# EPC DPW Stormwater\_2026-06-10\_004 - GEC Plans.pdf Markup Summary

## [45] G-1 GEC Cover Sheet (3)

GEC GENERAL NOTES

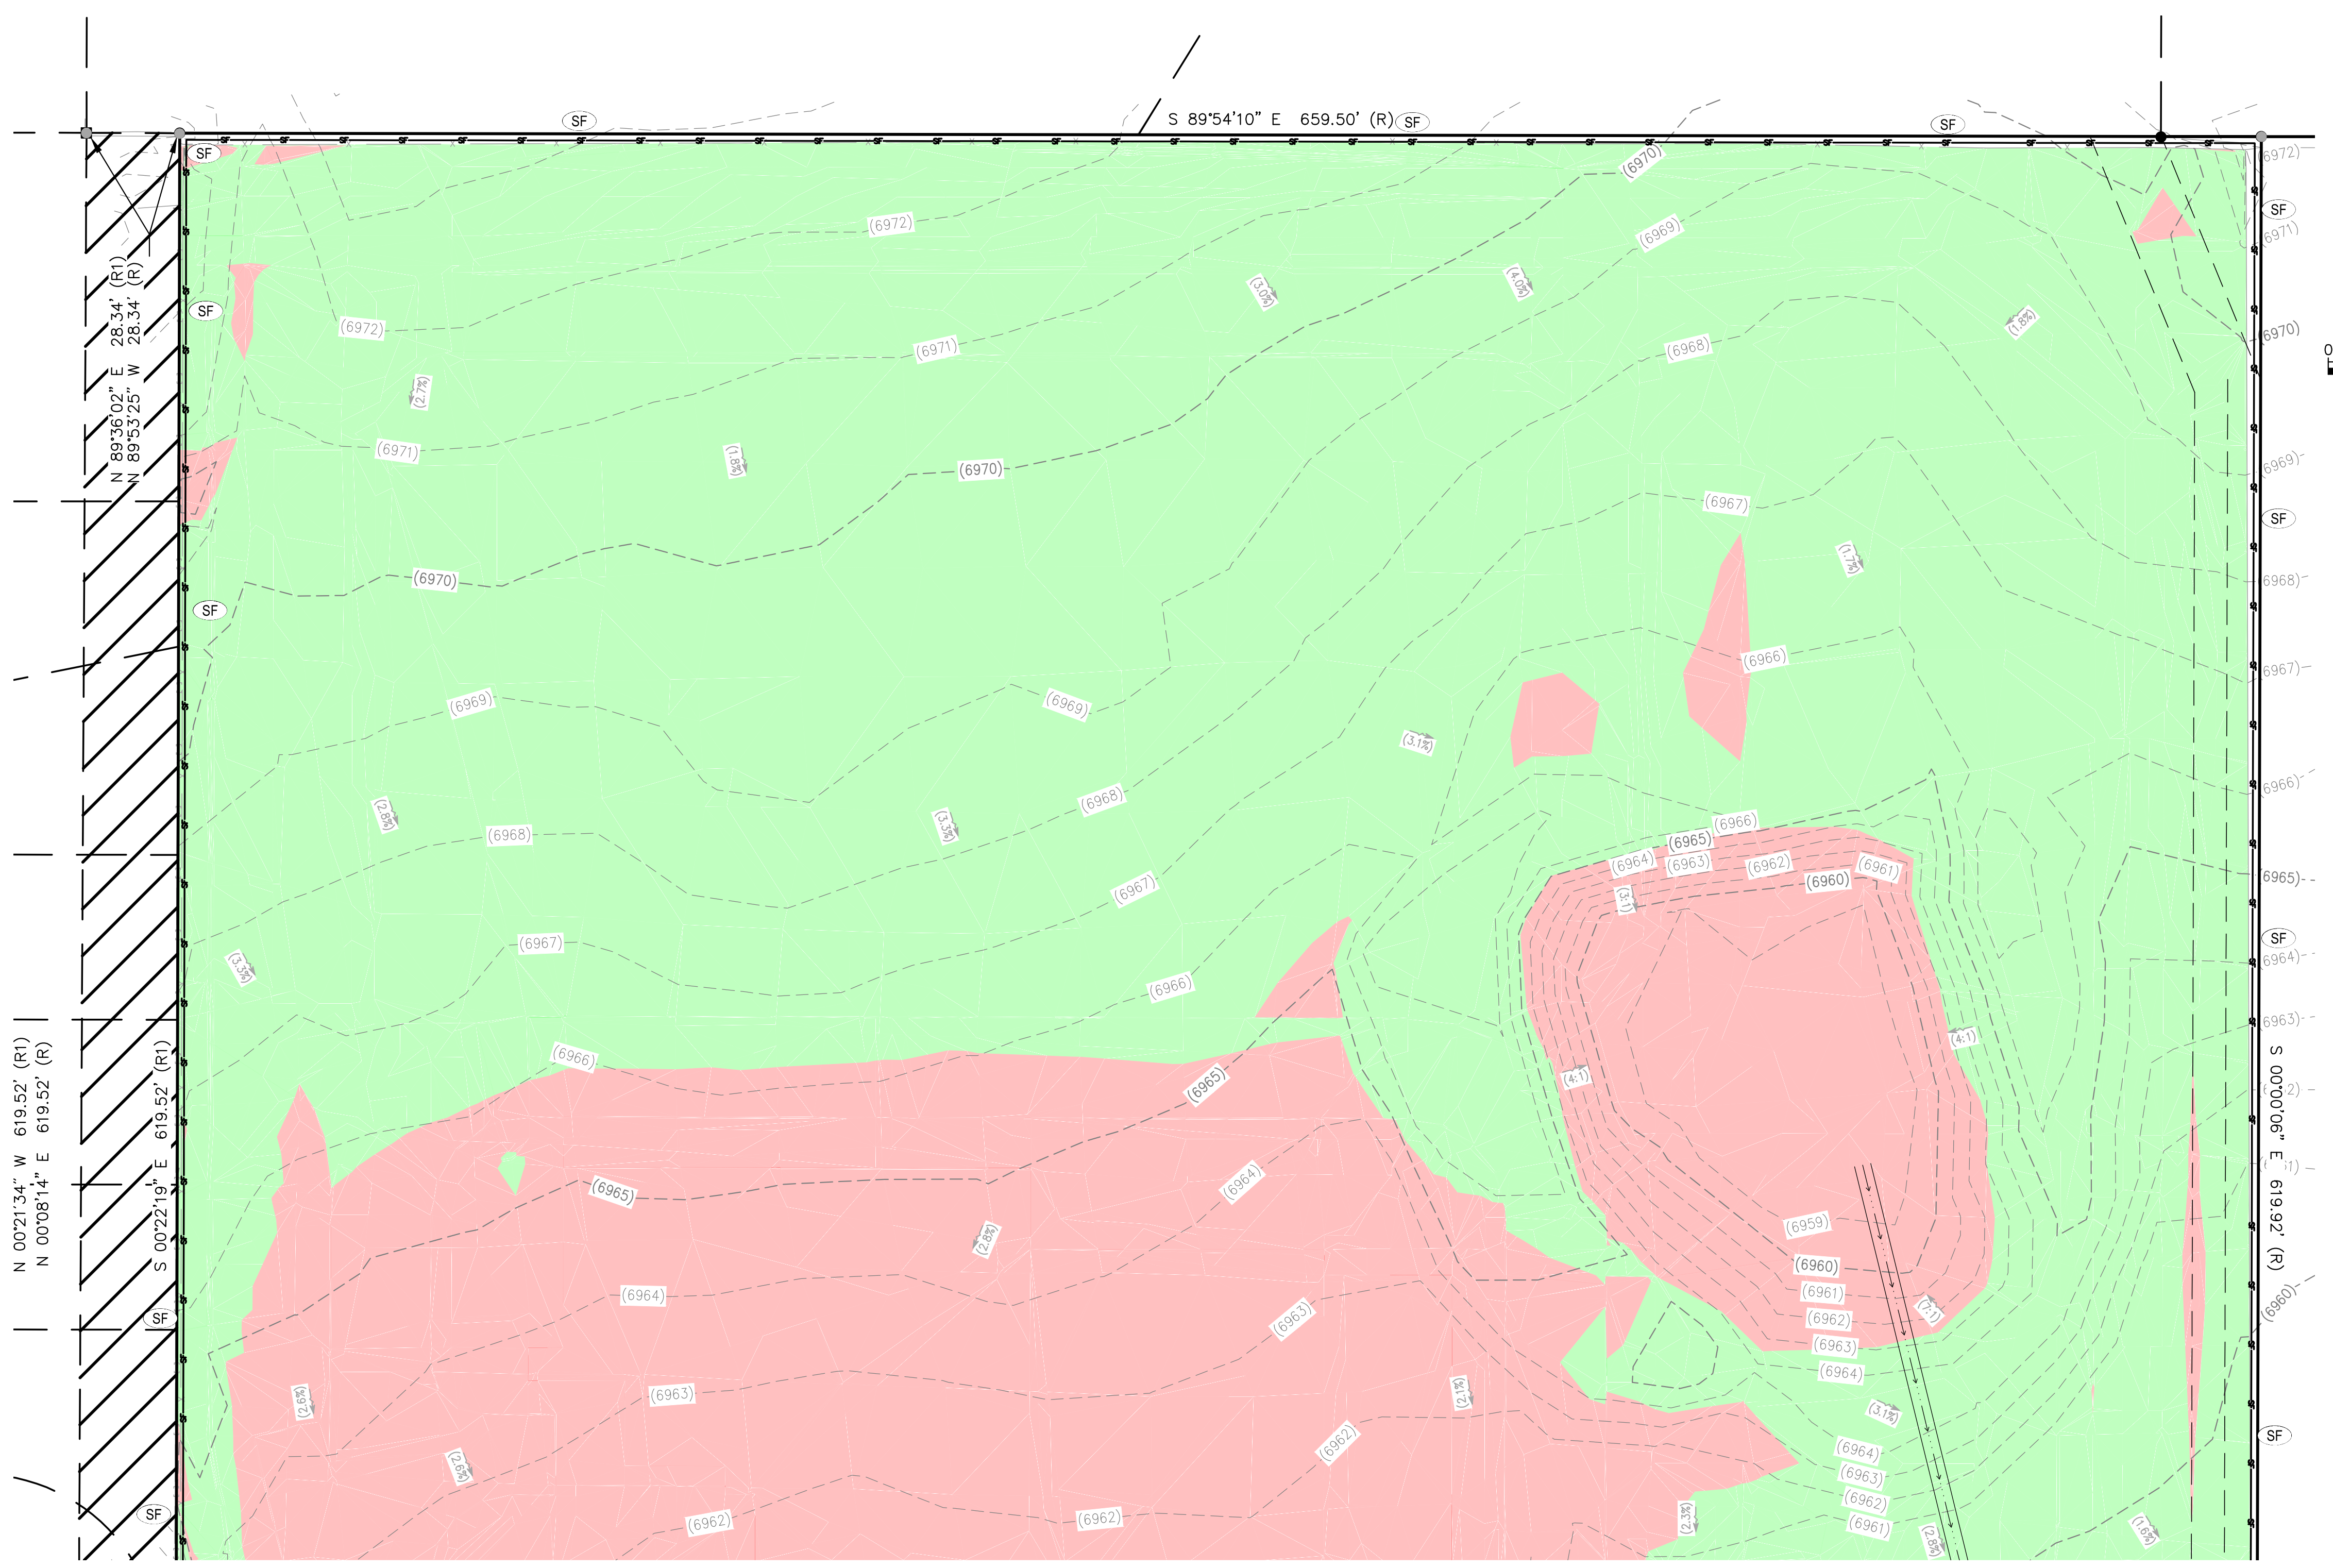
Use current notes for EPC grading and erosion control plans (attached or found in GEC Checklist)

TAIT Response:  
Notes have been updated to current.

G-3
OF
14

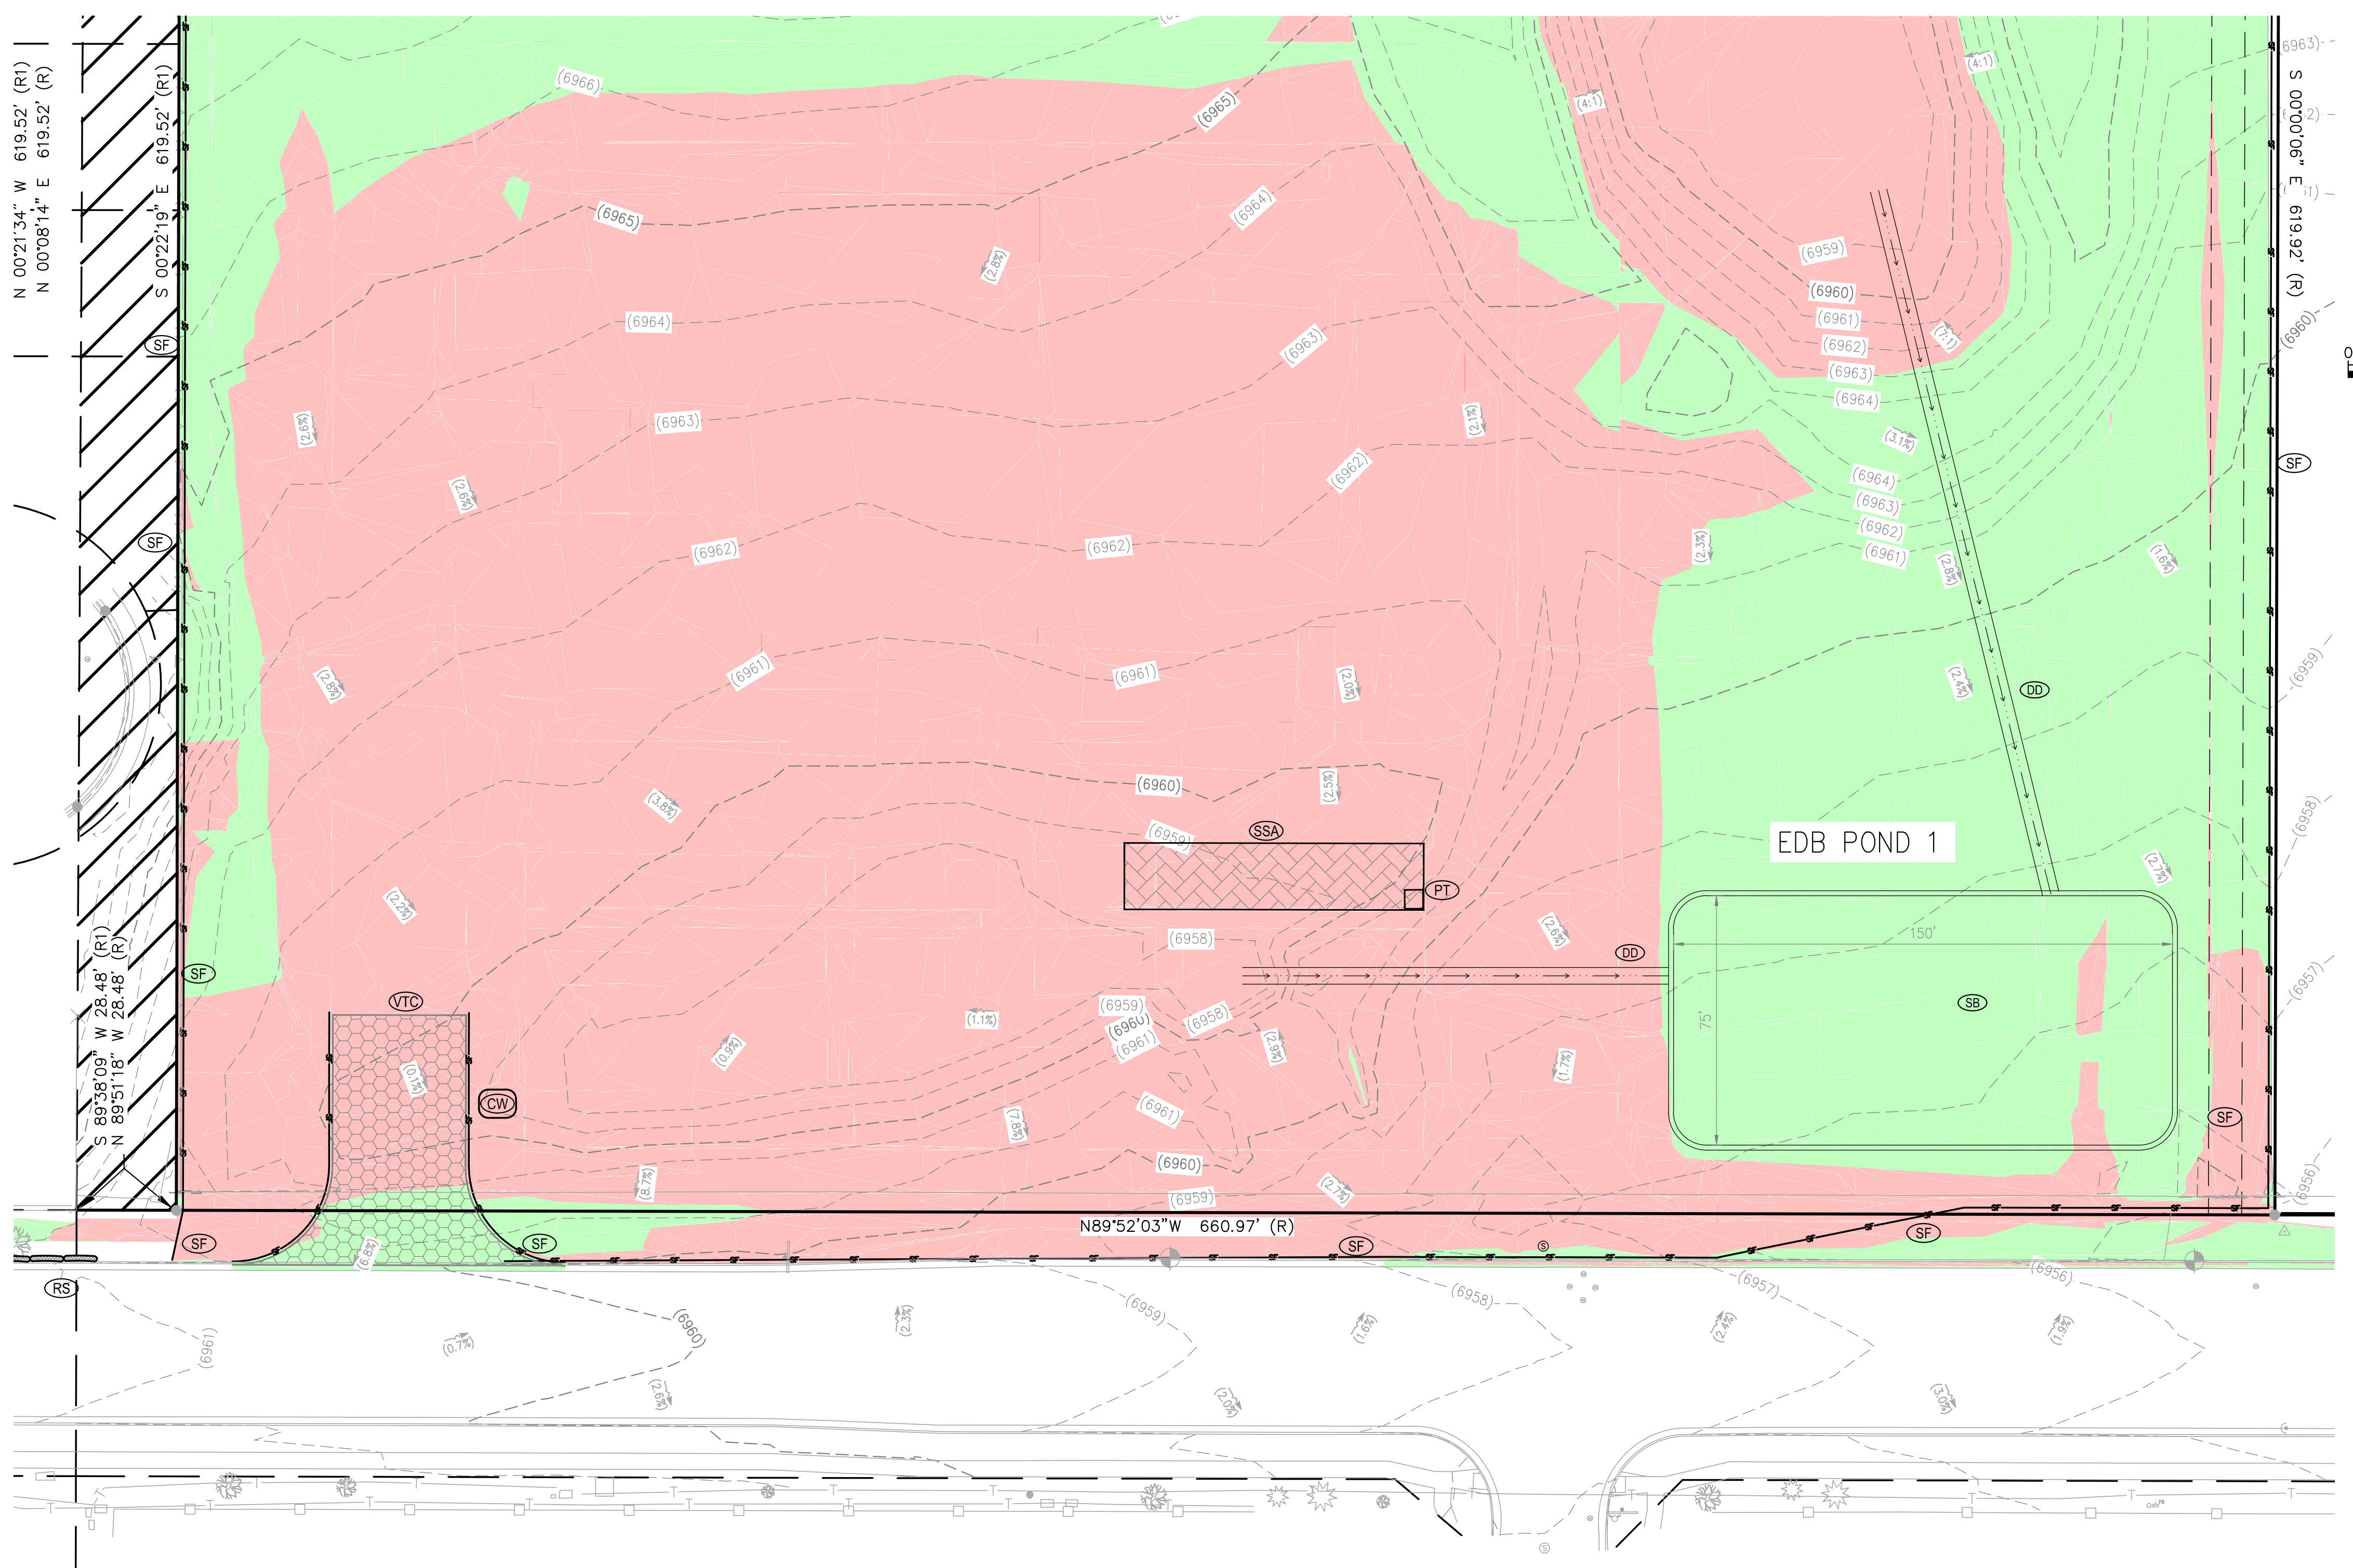
GEC Checklist Items L. If "limits of disturbance" and "construction boundary" are the same, change to "limits of construction/disturbance" or otherwise show as separate line types for each on the legend and figure.

GEC Checklist item K. Show existing vegetation (notes are acceptable in cases where there is no notable vegetation, only grasses/weeds, or site has already been stripped)

TAIT Response: Limits of Disturbance and construction boundary have been combined

TAIT Response:  
Note of existing vegetation has been added.

G-4
OF
14

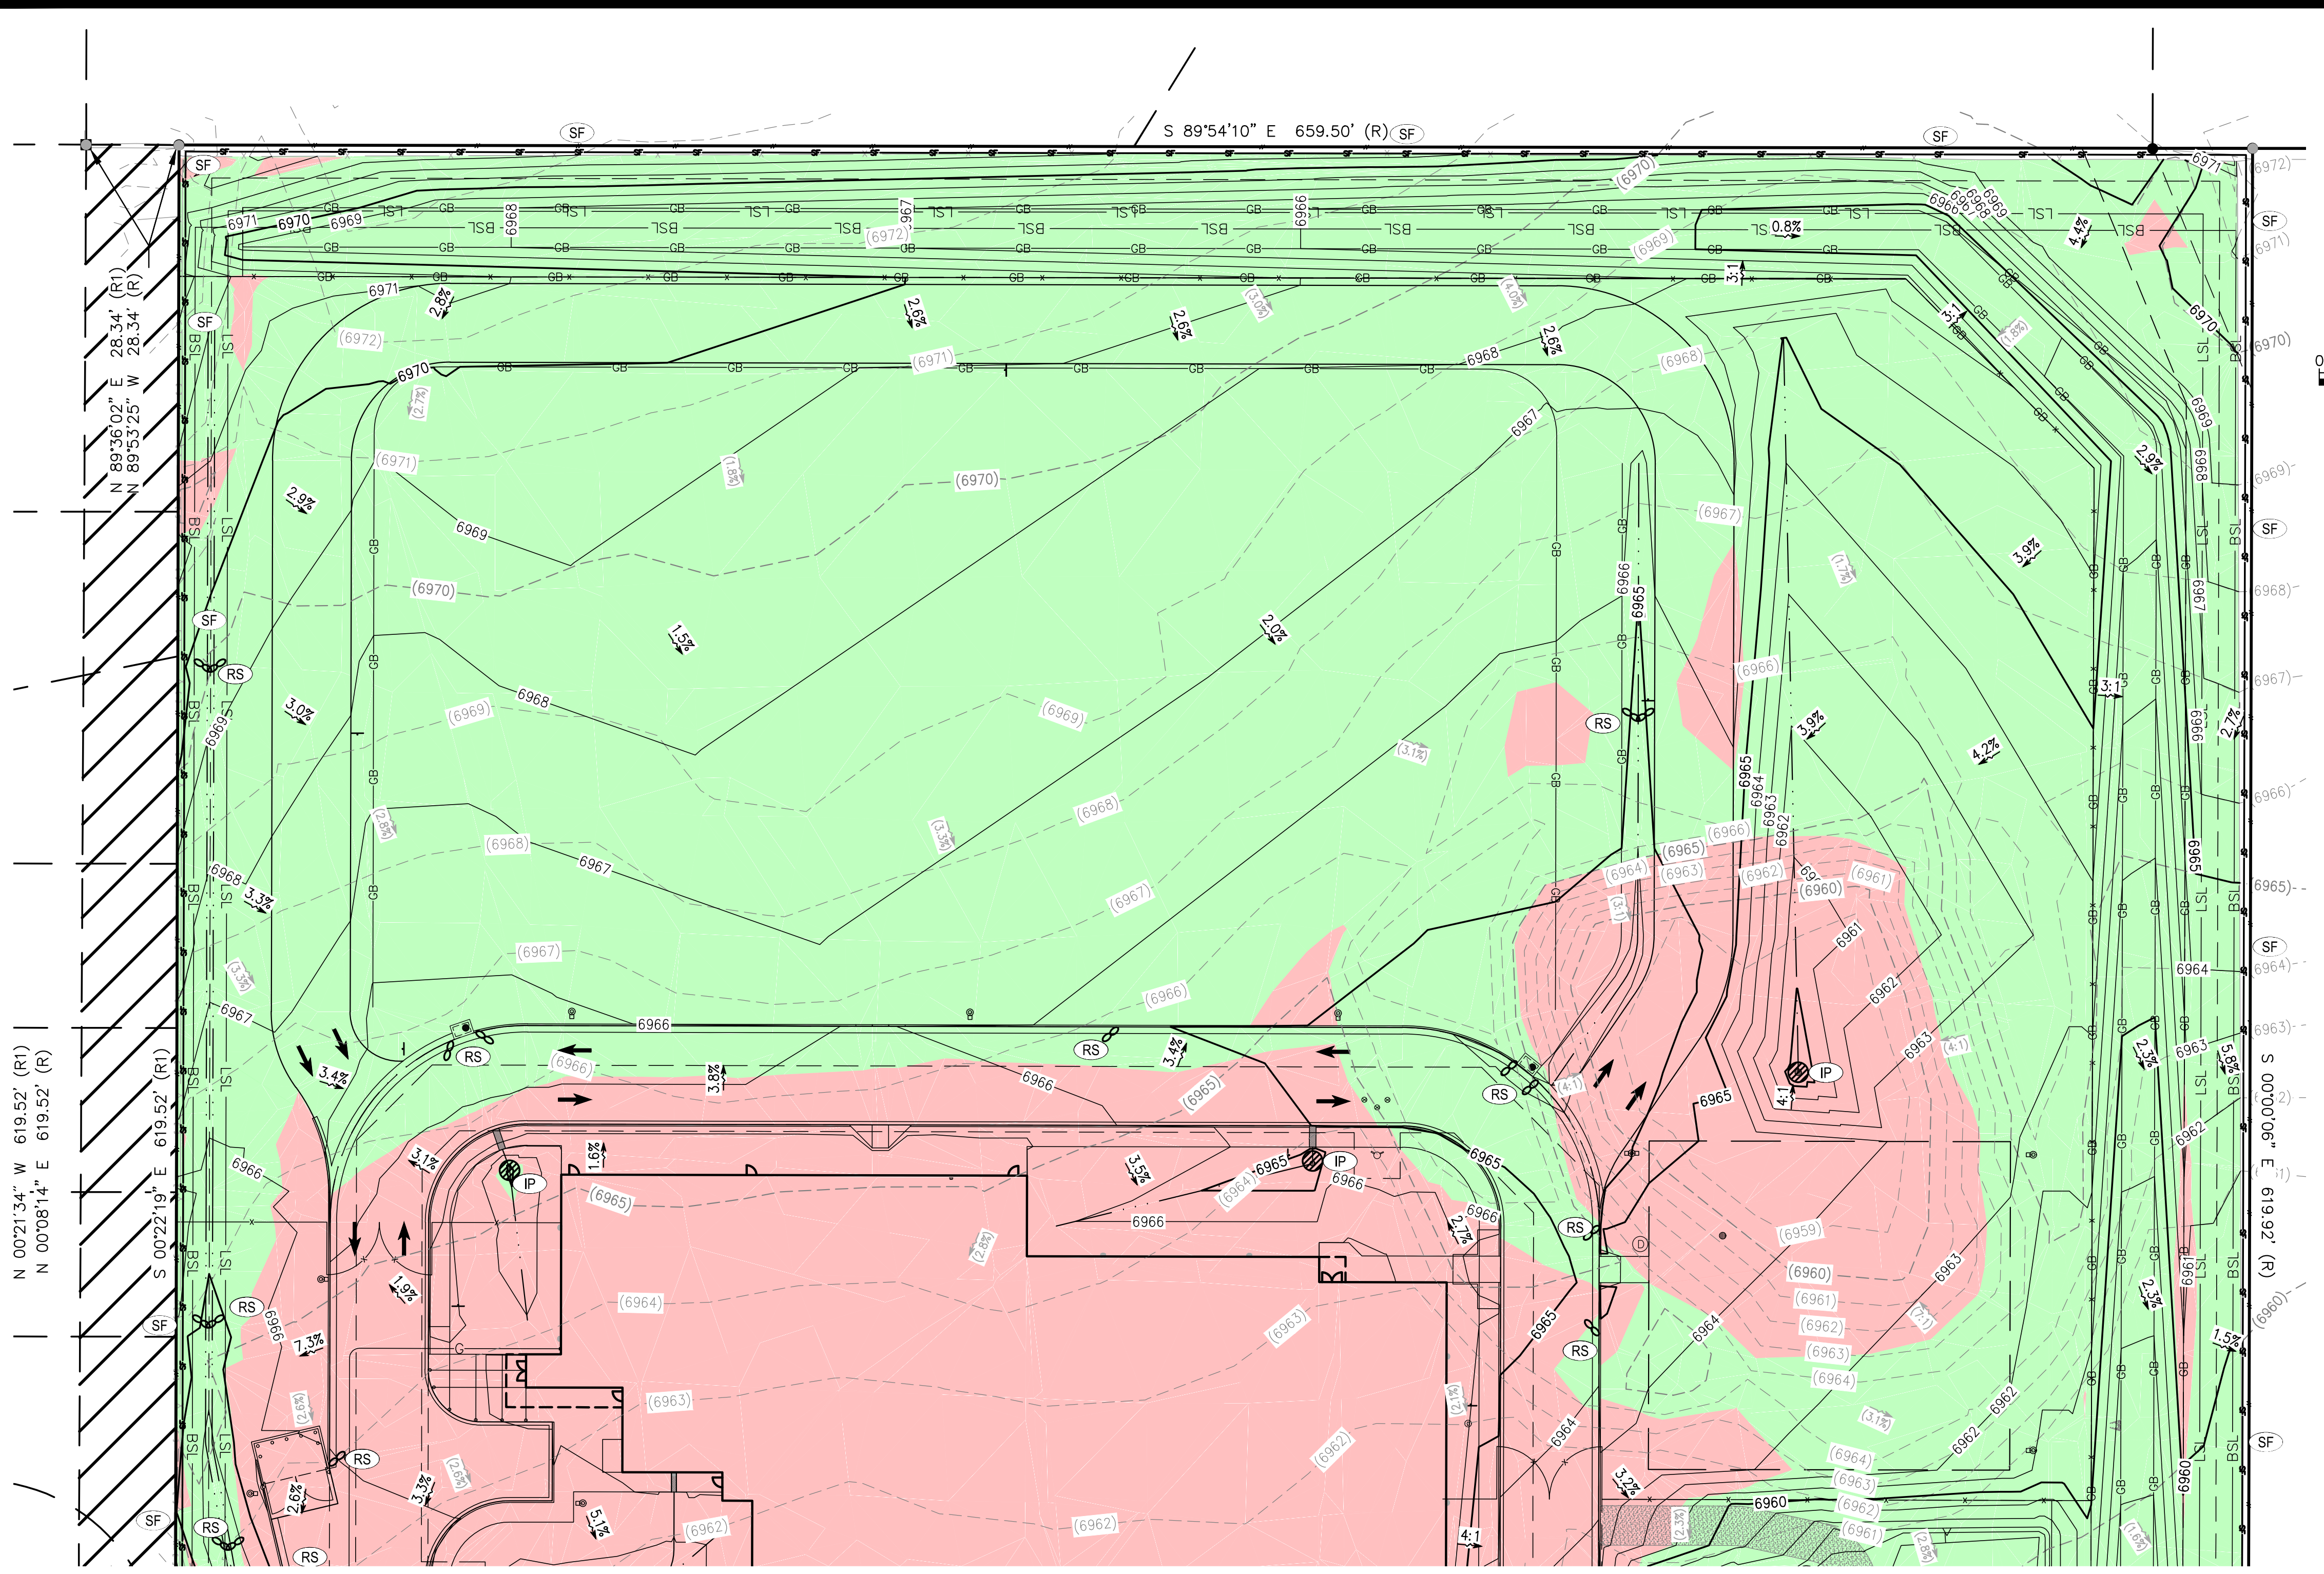
Please choose one or the other on the VTC, only one construction entrance will be needed

Sediment basins should be provided for disturbed drainage areas over 1 acre. Would it be possible to specify that these existing low areas remain until the pond is graded and a temp outlet is installed? Or could you phase it so the pond grading (with temp or permanent outlet) and diversion ditch are installed initially?

The silt fence alone isn't suitable for the size of the drainage area, please provide additional BMPs to treat the runoff from the disturbed areas.

Show on plans

TAIT Response: Left VTC has been removed.

TAIT Response: Left Sediment basins and related items have been added.

TAIT Response: Diversion ditches added to plans.
